From: Michael Eastham <Michael.Eastham@arun.gov.uk>
Sent: 27 April 2021 17:08
To: Planning.Responses <Planning.Responses@arun.gov.uk>
Subject: FW: *EXTERNAL: RE: Felpham - FP/248/20/PL

The hard landscaping items contained in dwgs BDWS23254 11 Rev. A - Hard and Soft Landscape Proposals (Sheet 1) and BDWS23254 11 Rev. A - Hard and Soft Landscape Proposals (Sheet 2) cycle stands, benches and bins, would appear suitable and appropriate for location.

date: April 2021
scale: 1:250@A1
drawing no: BDWS23254 11 Sheet 2
drawn: JM checked: DKM

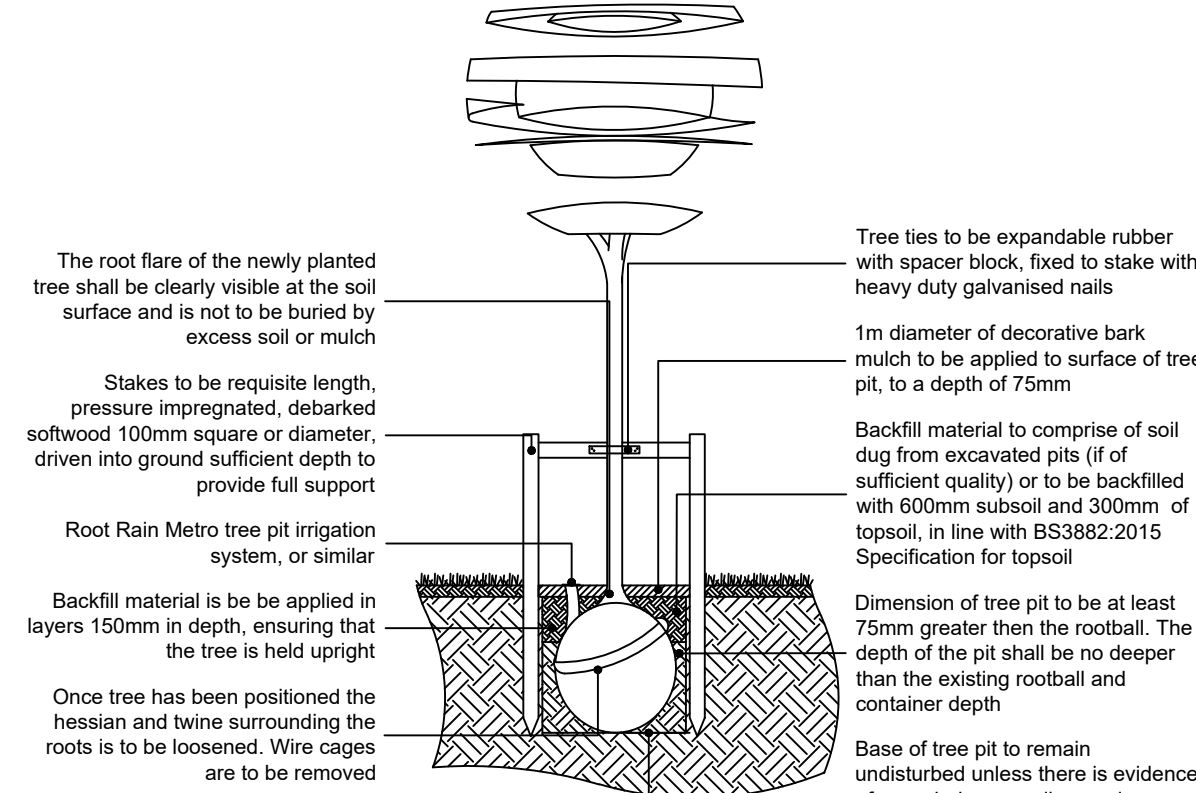
I would recommend approval of these items under application FP/248/20/PL
